After reading the both the Applicants' Responses to the Written Representations, and the Examiner's Second written questions, I wish to make the following points.

7.5 Habitat Constraints Plan

Drawing Title	<b>SuDS Schematic</b>	Scale	<b>NTS</b>
	Drawing Number	-	Revision	<b>0</b>
	Project Name	<b>Oaklands Solar Farm</b>	Drawn by	<b>JEM</b>
	Project Number	<b>P20209</b>	Checked by	-
	Client	<b>BayWa</b>	Notes	© Crown copyright 2023 OS 100062269

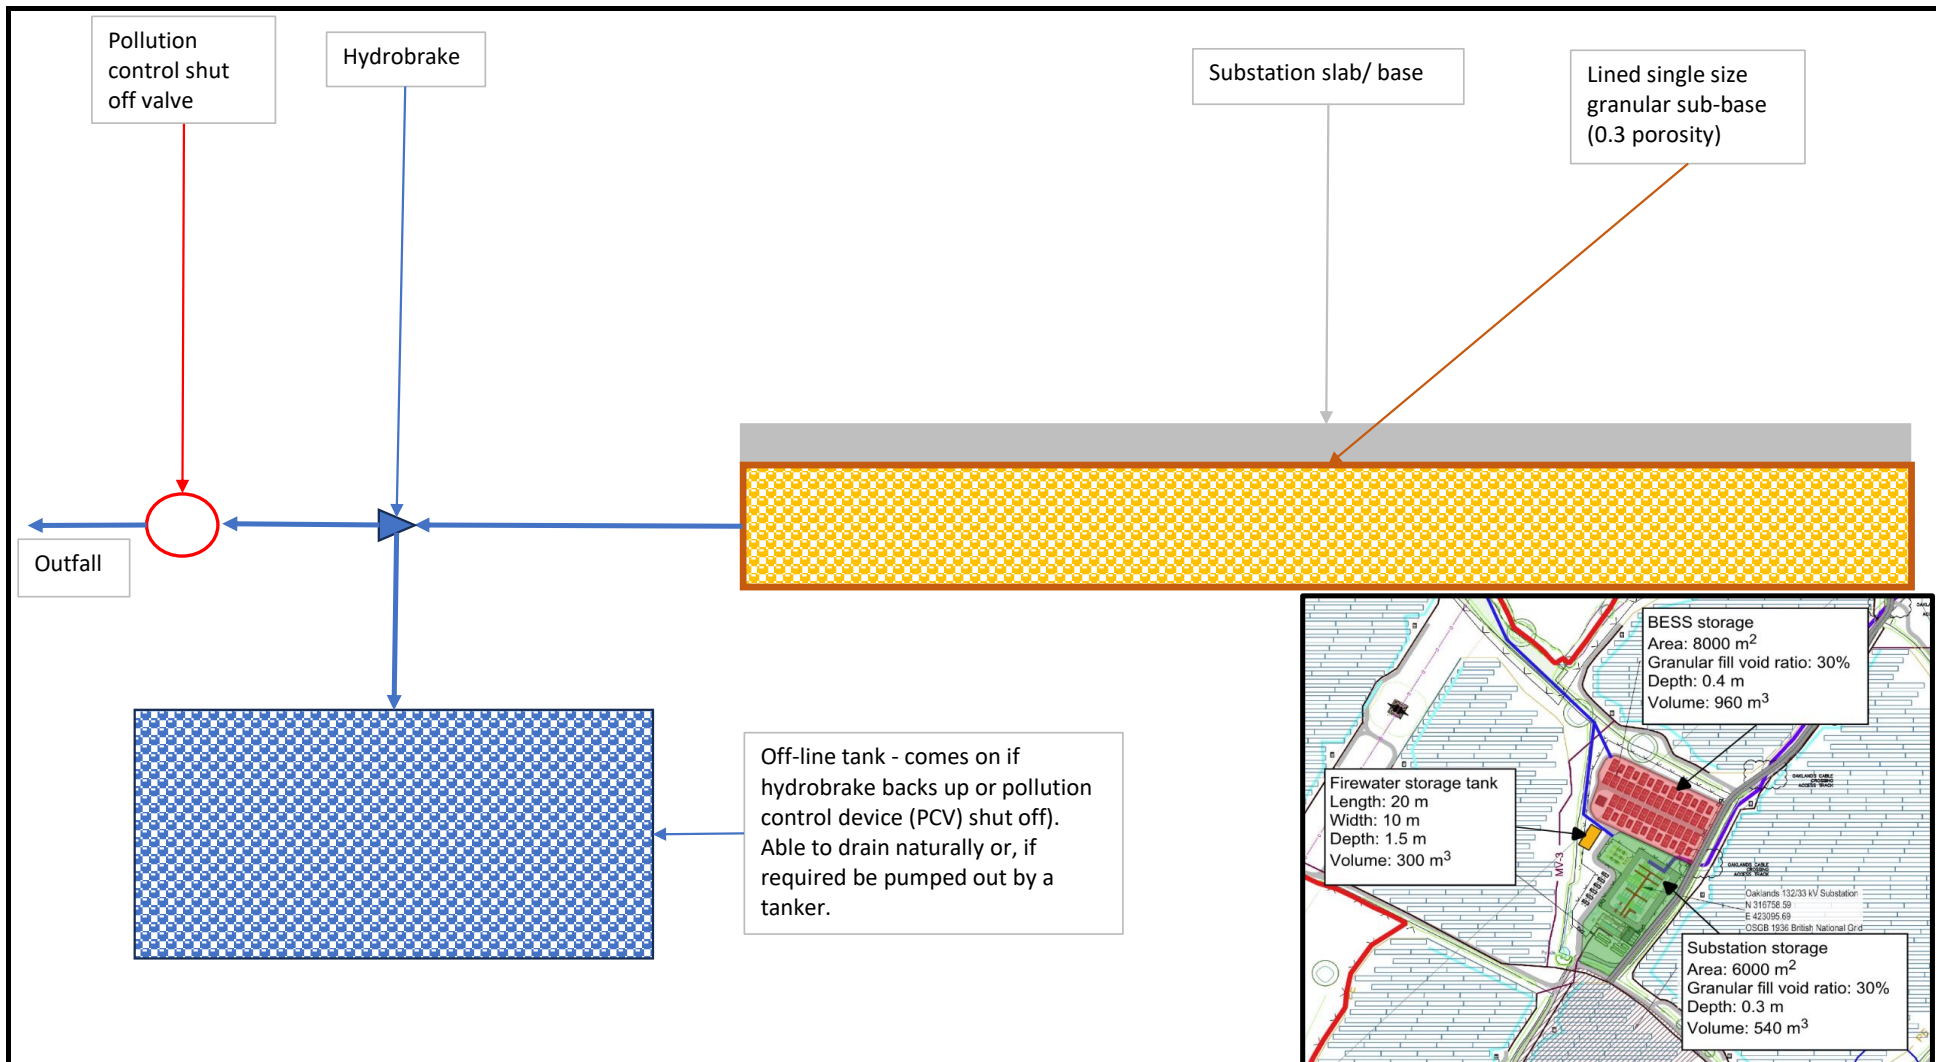
In Section 13.148 (ES Climate Change) the Applicant states that climate change may account for increases in rainfall of between 15% and 35%. Yet the BESS water storage facility is only sized to store "1% Annual Exceedance Probability + 25% storm event". There is no comment on the additional storage also required to contain fire suppression water, and how it might be managed if a fire occurs just after a storm event, when the storage tanks are still full. Nor is the total storage capacity of the tanks / bund referenced (as far as I can tell).

Oaklands Farm Solar – Suggested Site Inspection Locations from SDDC – Map (Amended August 2024)

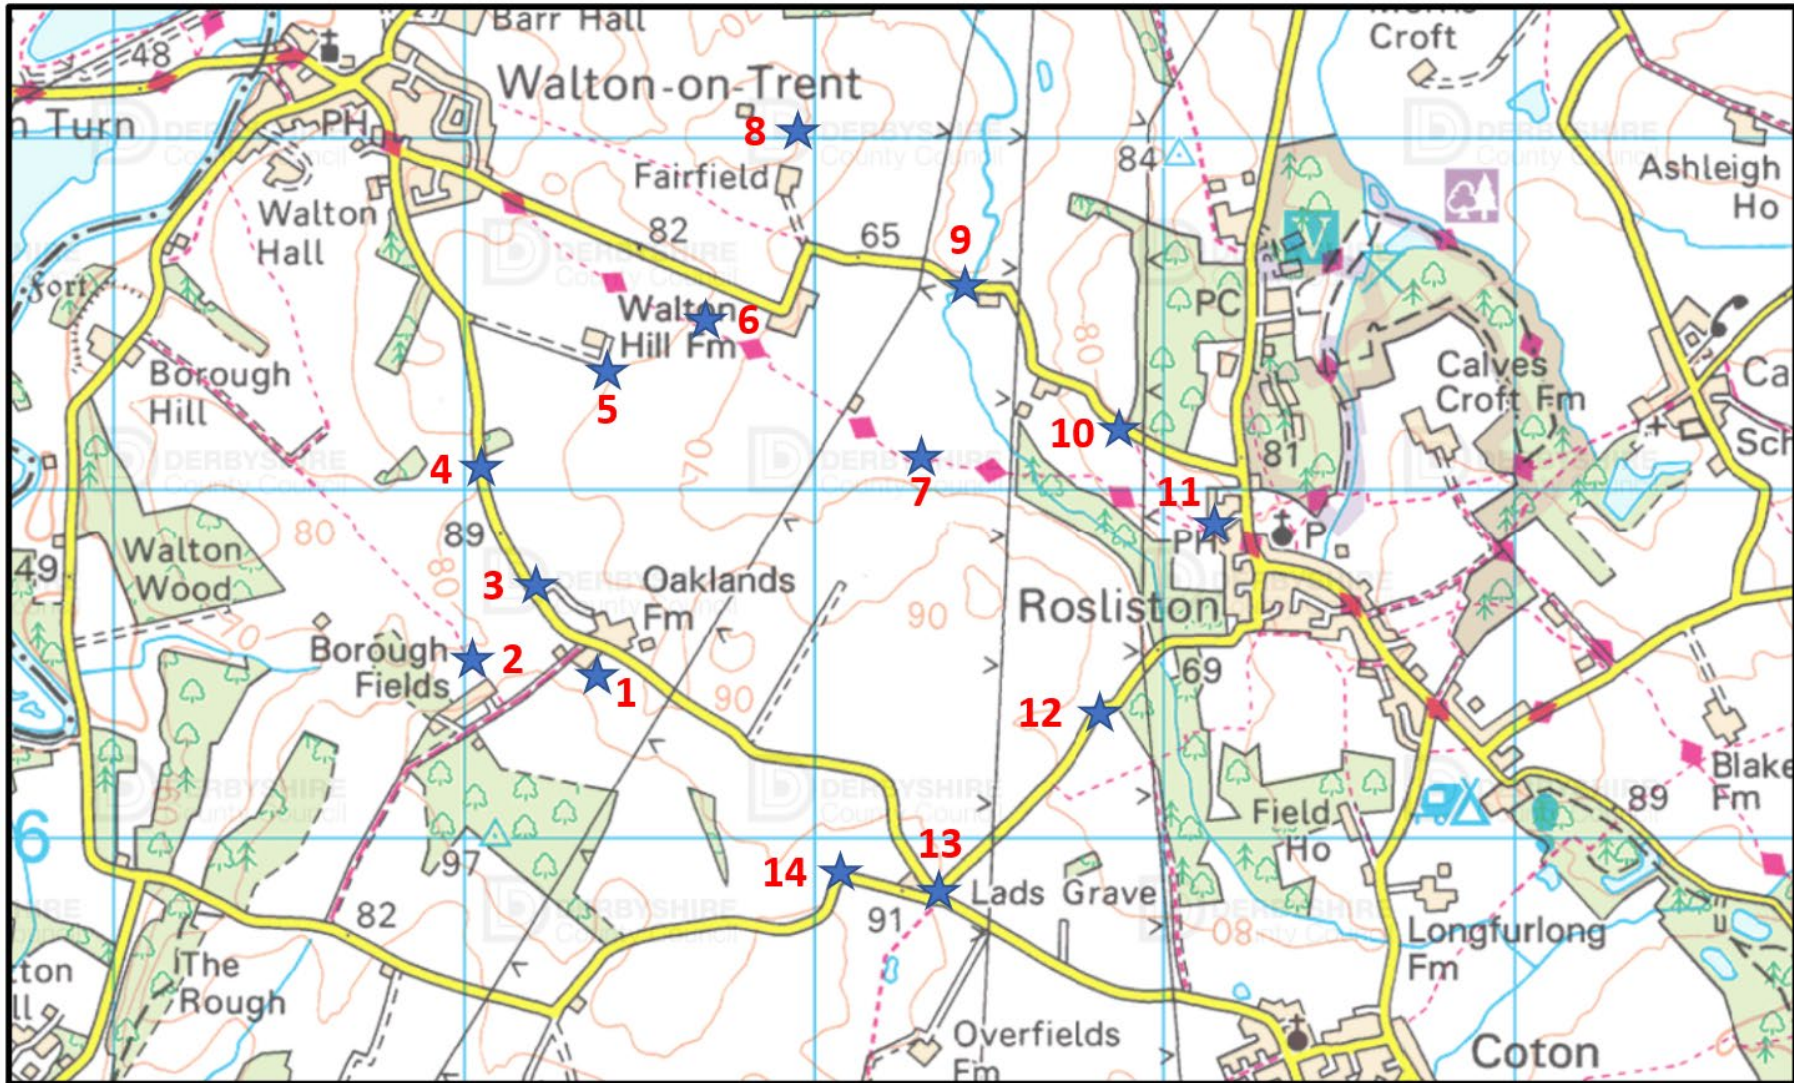
If new representations are required to assist the landscape assessment; I would suggest some alternative viewpoints are modelled that better reflect the scenic vistas that are seen by residents and local road users, as outlined by SDDC at Deadline 1 (particularly points 3, 10 & 13). See EN010122-000448 - Suggested Site Inspection Locations.
